CITY OF ALBUQUERQUE
MUNICIPAL DEVELOPMENT DEPARTMENT
ENGINEERING DIVISION

REF: TRANSAMERICA PLAZA TRACT 2-B-2 (H18-D17A)

Based on the information provided on your February 3, 1984 submittal of the above referenced drainage report, listed you will find certain items that will need to be addressed before final approval is granted:

Based on the information provided on your April 20, 1984 resubmittal of the above referenced drainage report, listed you will find certain items that will need to be addressed before final approval is granted:

TYPICAL SECTION DRAIN ON UNDERGROUND PARKING ROOF SLAB ADJACENT TO WEST PROPERTY LINE
scale: 1" = 1'

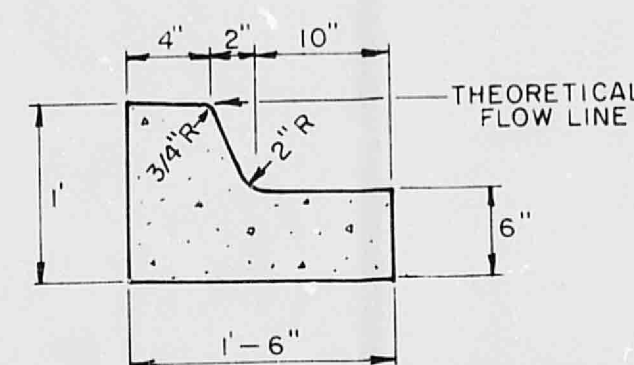
The client has expressed a desire to plant 2 trees with tree wells within the drainage outlet located on the west side of the property. Attached are calculations that show no impediment to the drainage runoff.

Check effect of proposed planters
 on flow to west.

LANDSCAPING PLAN DRAINAGE DETAILS
not to scale

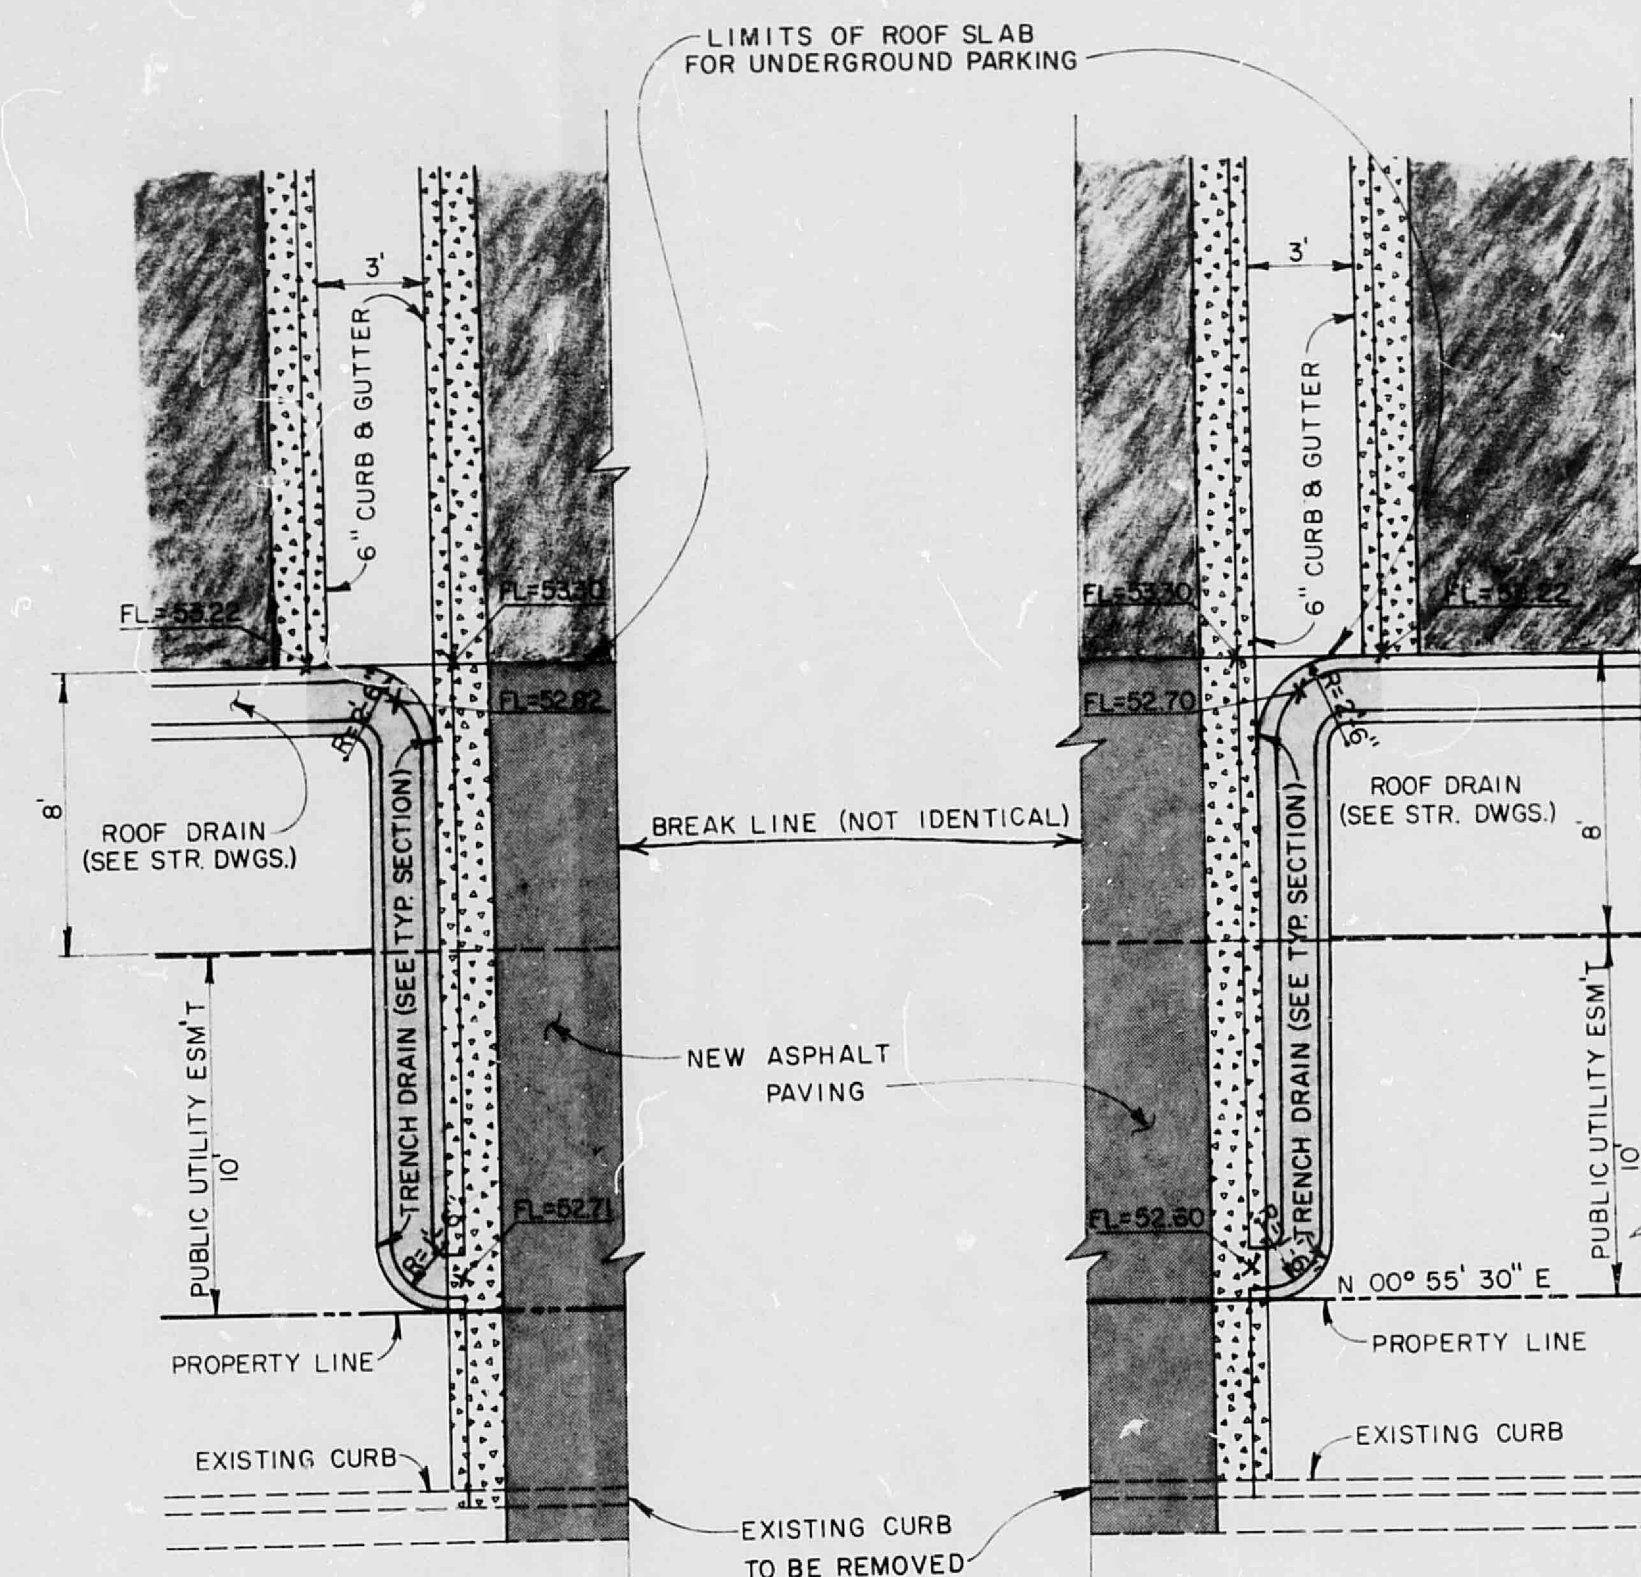
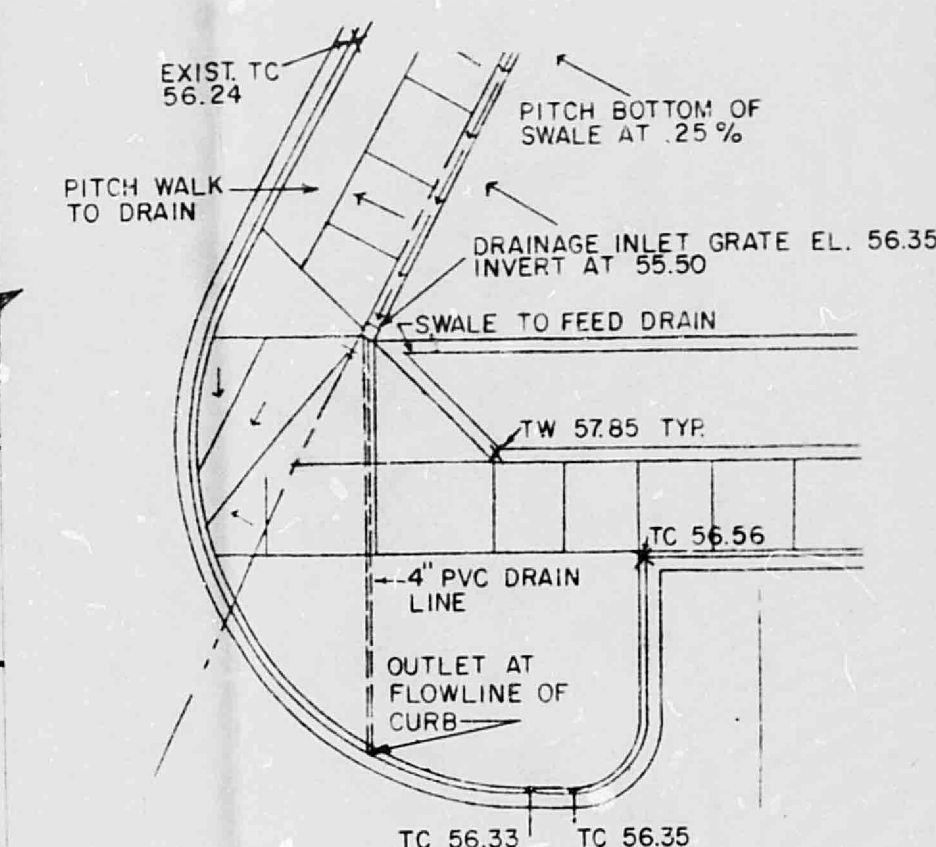
1. Complete information sheet on resubmittal.
2. Professional's stamp with signature and date on all applicable drainage sheets.
3. On the far north portion of the plan you make a notation (see landscaping plans for drainage details in this area). Please incorporate all applicable drainage information on drainage plan alone. (We don't check the landscape plan).
4. Vicinity map showing location of development. (We do not use the conceptual grading and drainage plan for our final inspection.)
5. Benchmarks-location, description and elevation of the:
 - A. Albuquerque Control Survey Vertical Datum.
 - B. Temporary benchmark on-site.
6. Show location and direction of all downspouts, please identify on plan.

1. Complete information sheet required with resubmittal.
2. Professional's stamp with signature and date on all applicable sheets of the engineer who prepared the revised drainage plan.
3. Please incorporate the drainage details from the landscape plan onto sheet C-1 of the drainage plan. Also it is advisable that you route the 4" outlet pipe from the trench drain to exit directly onto the paved area via through the curb.
4. Your drain inlet detail should be incorporated on Sheet C-2 along with the other details. These will eliminate the small attachments to the plan.
